From: Sean Pope [REDACTED]
Sent: 13 June 2018 18:16
To: Pat Aird
Subject: RE: FG/42/18/HH 17 Foamcourt Way

From: Pat Aird <Pat.Aird@arun.gov.uk>
Sent: 13 June 2018 12:28
To: Sean Pope [REDACTED]
Subject: FG/42/18/HH 17 Foamcourt Way

PROPOSED SITE PLAN

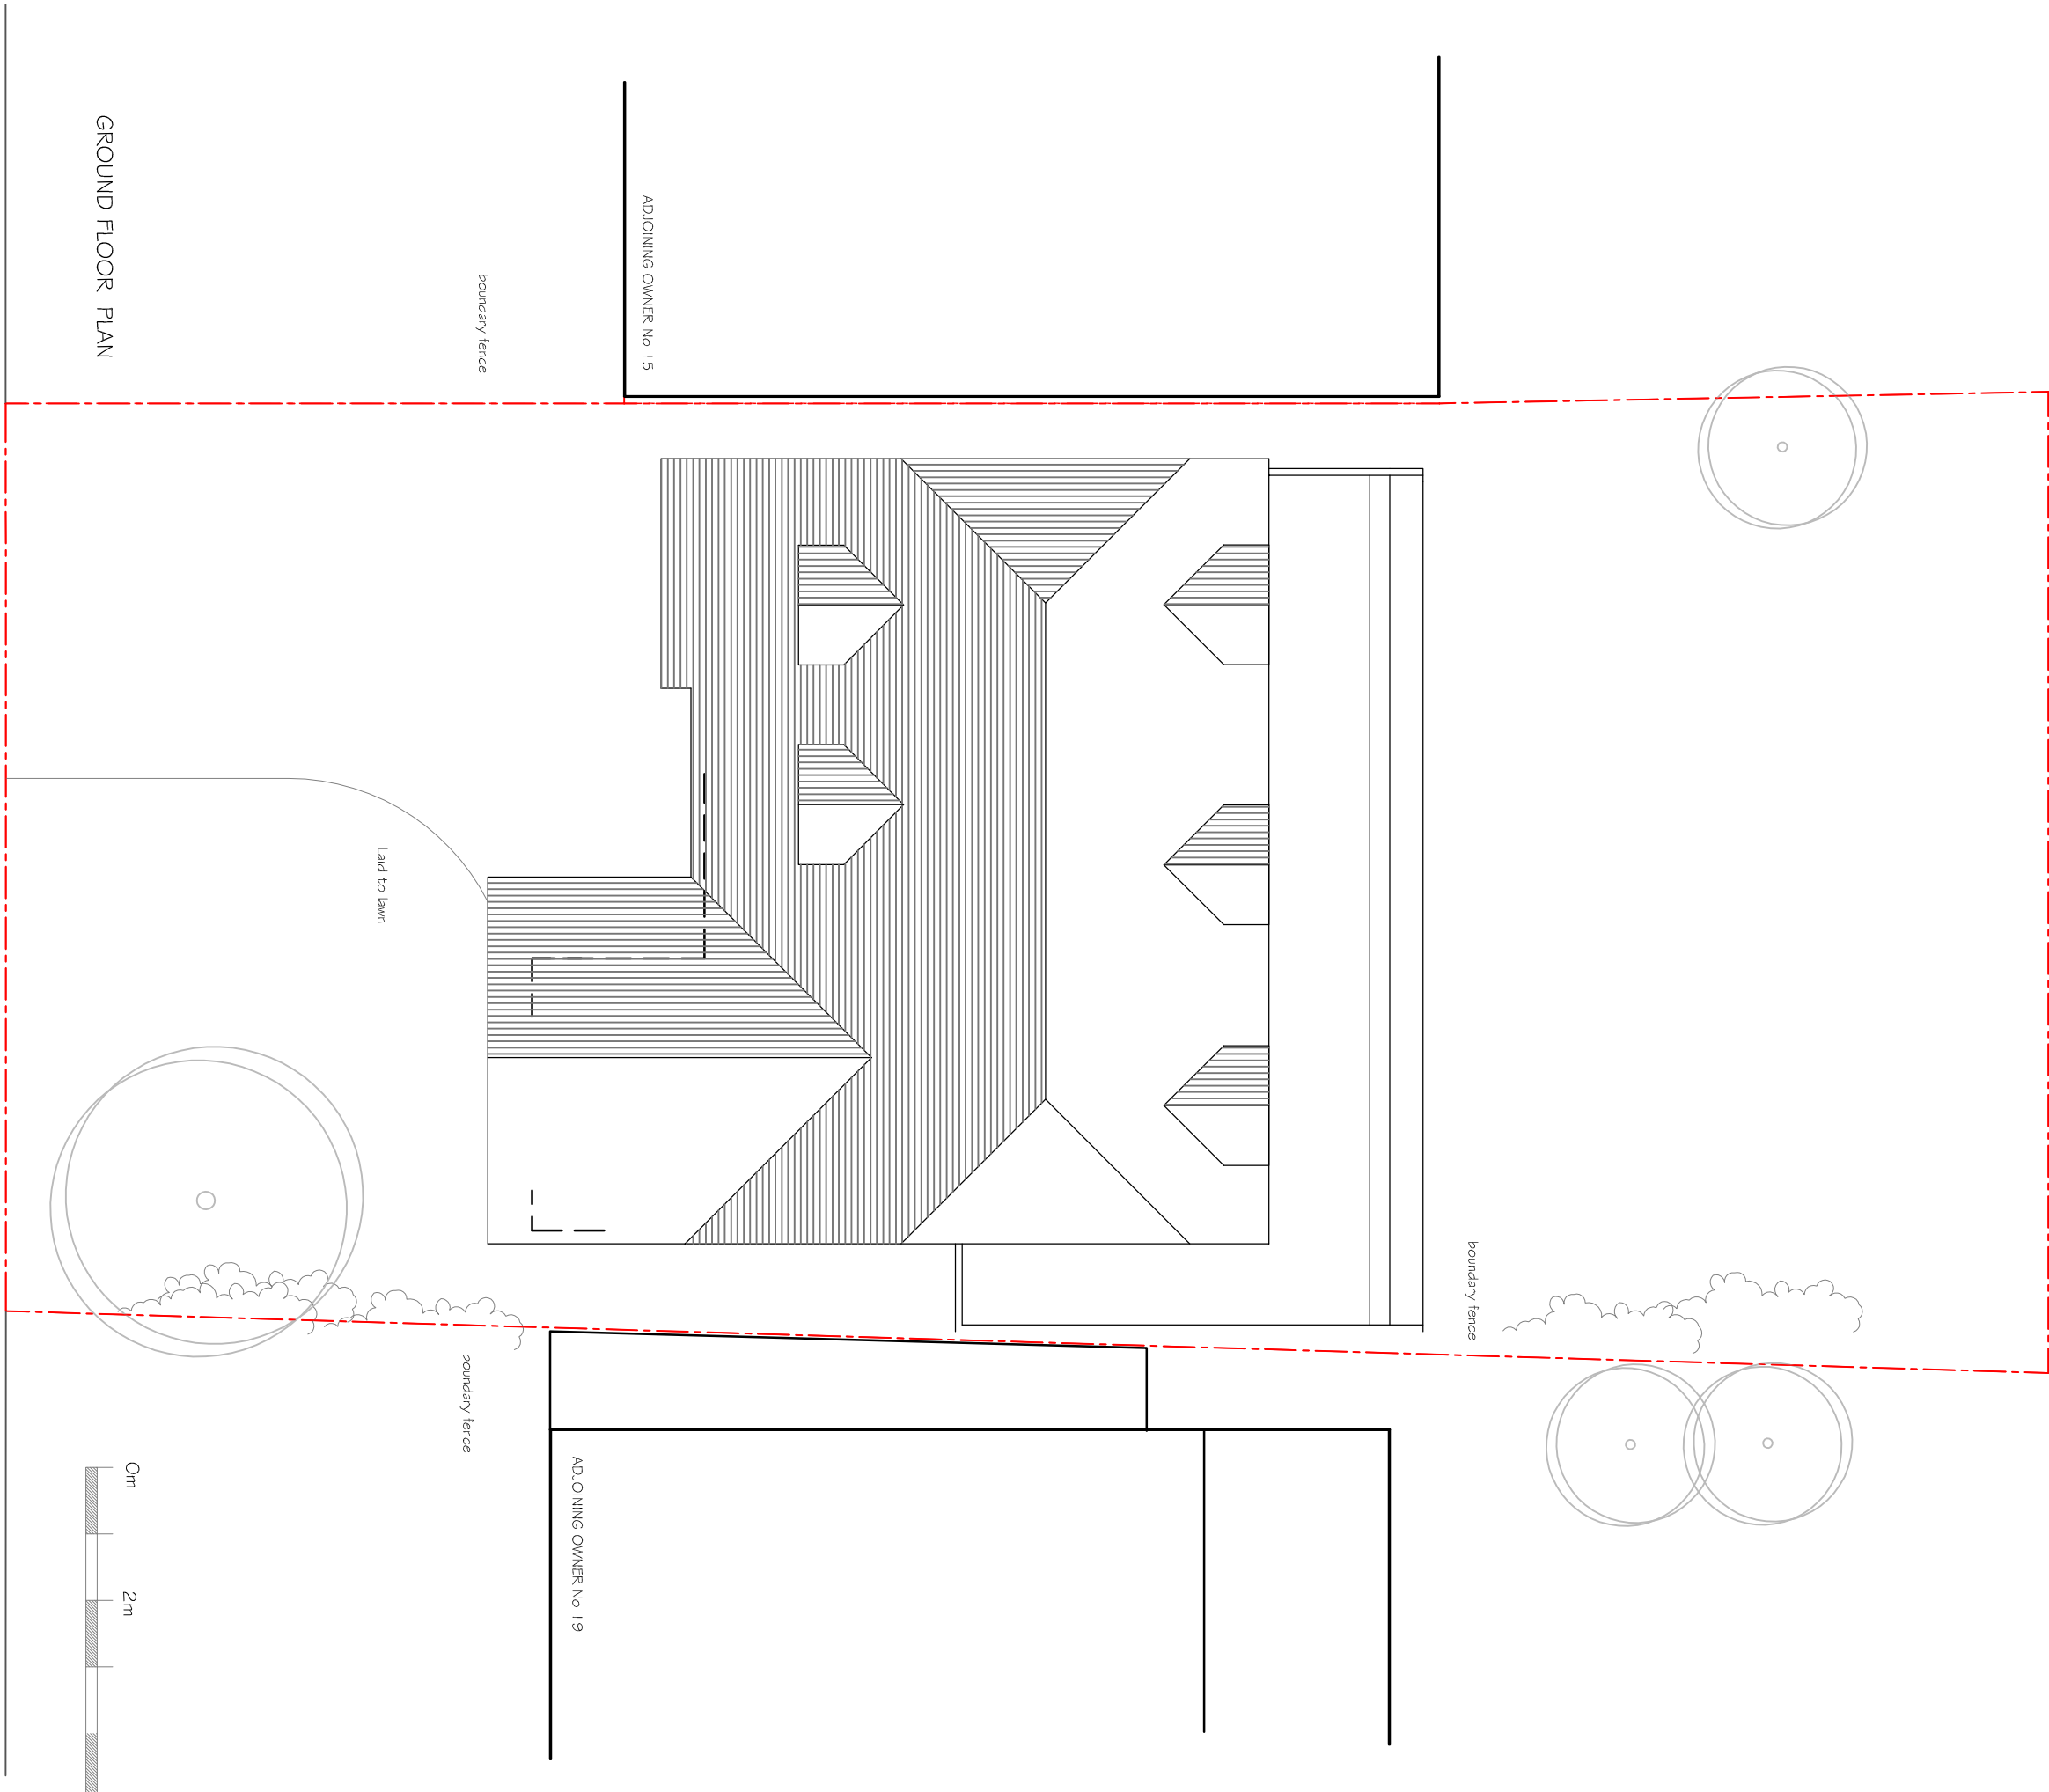
It has come to my attention that the proposed site plan drawing no 1718/11 has been erroneously labelled at a scale of 1:200 whereas in assessing the proposal I note it must be at a scale of 1:100. Please could you confirm .

Please find attached my amended drawing for your use. I have altered the drawing to a scale of 1:100 as requested.
